Application for a Non-Material Amendment Following a Grant of Planning Permission

219 Preston New Road

Proposed elevations Rev A

1:100 PROPOSED ELEVATIONS

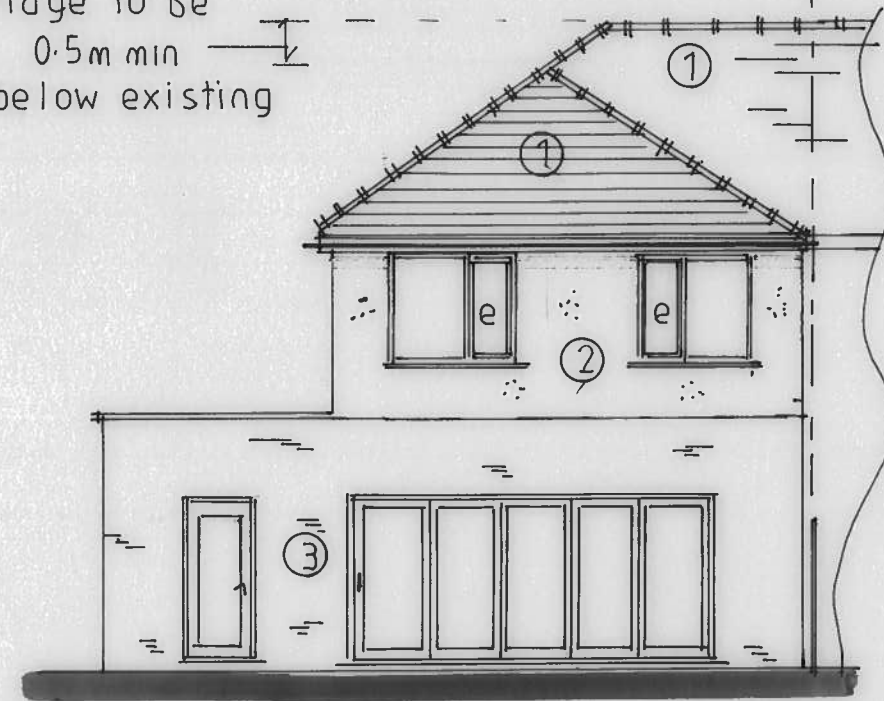
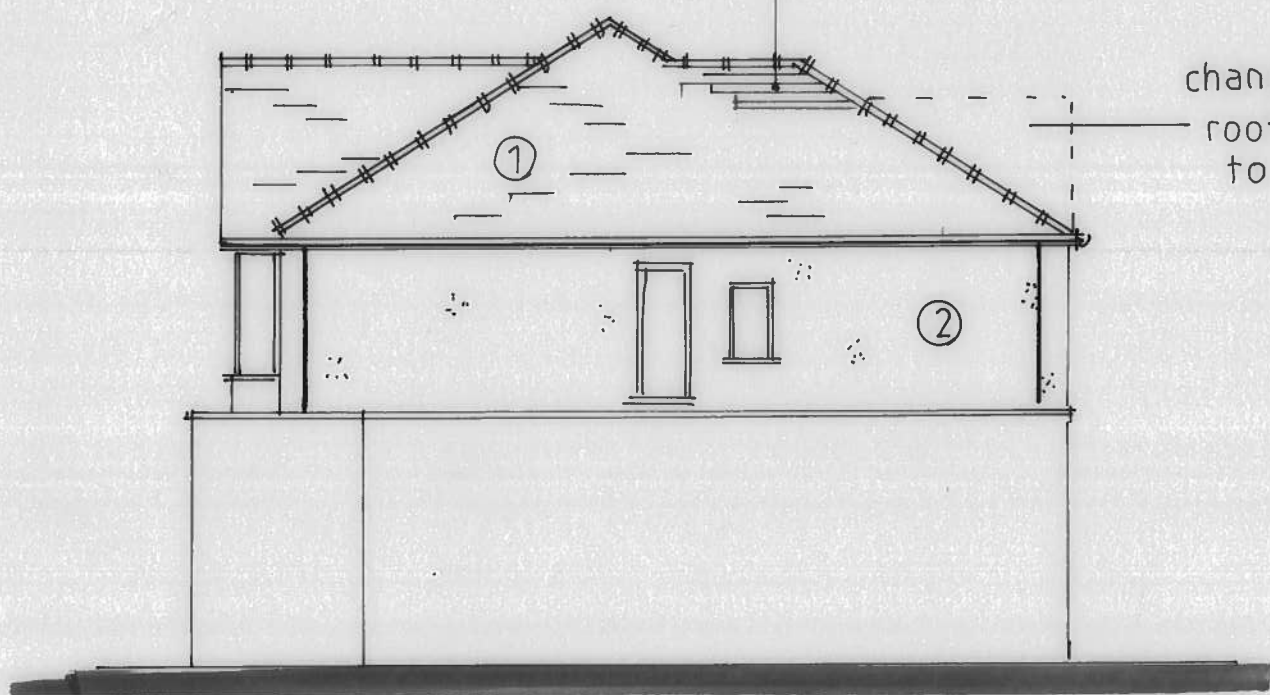
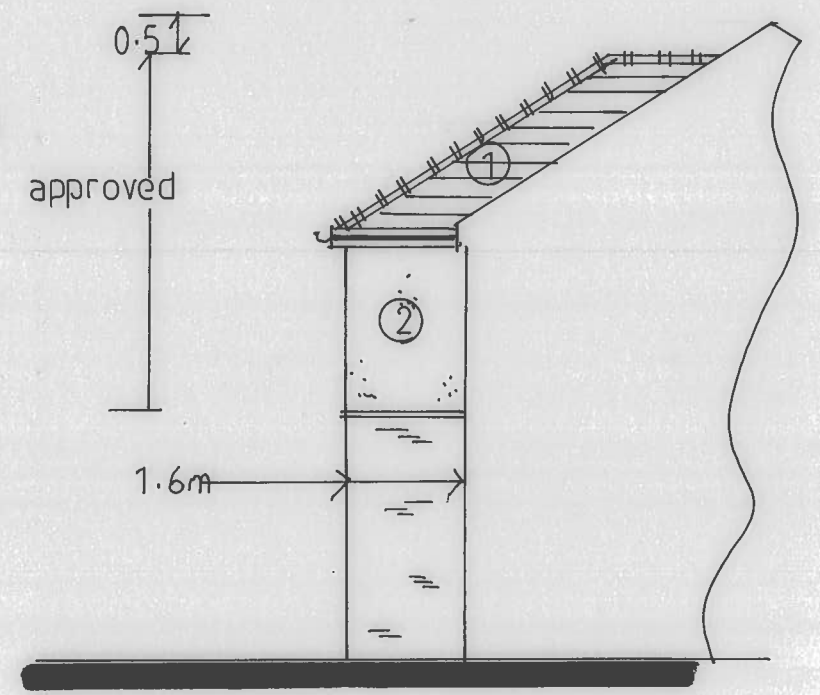
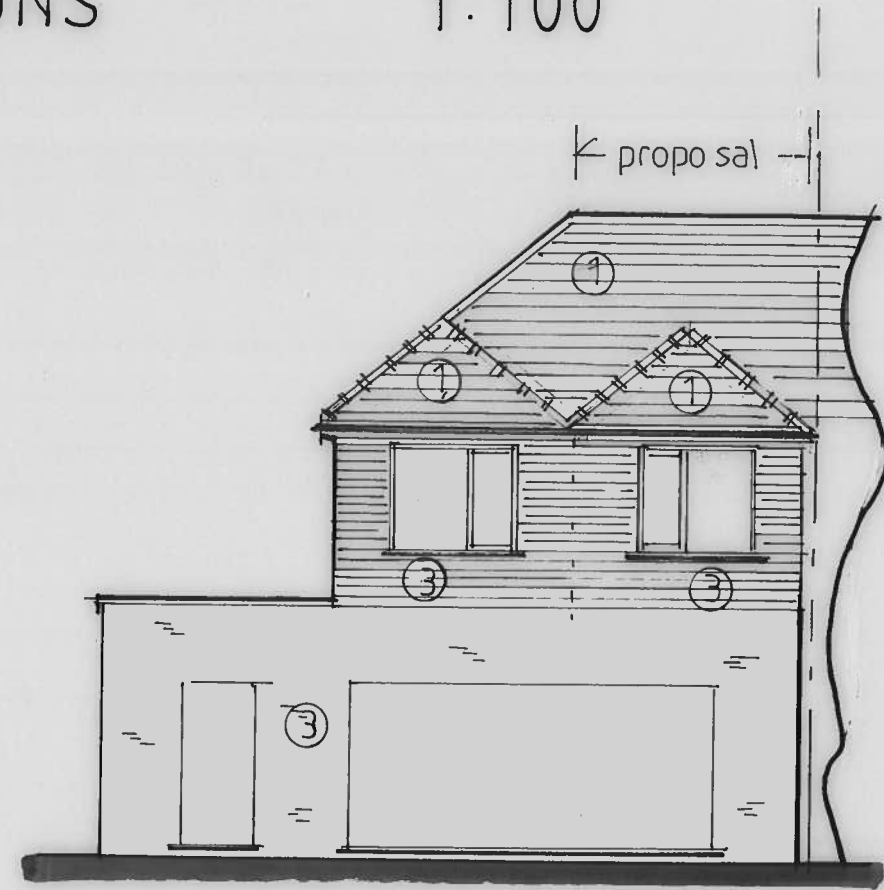
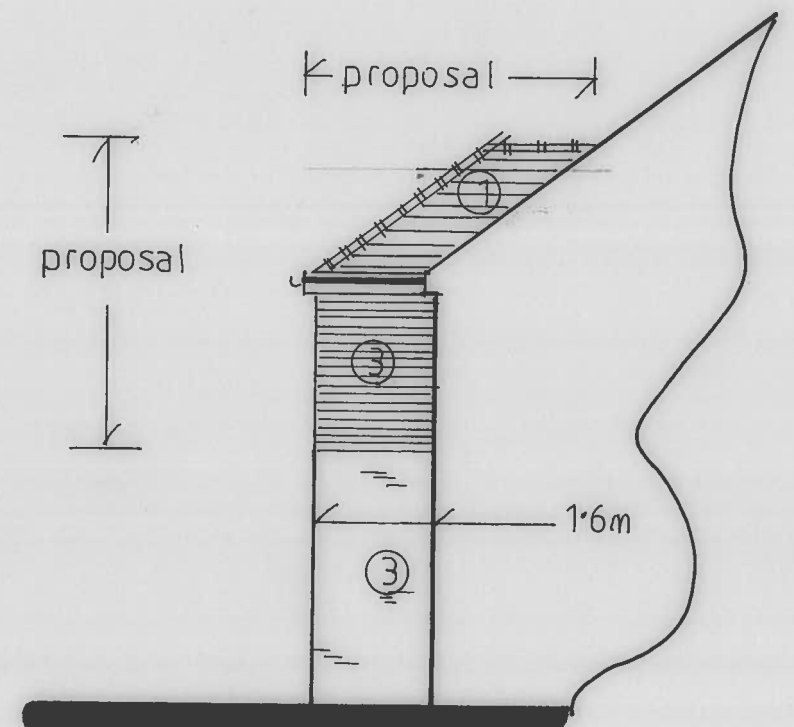
The approved design is causing problematic to construct and a smpathetic alternative is proposed which would still be in harmony with the existing dwelling.

Agreed in principal , new roof to be 500mm below main ridge level
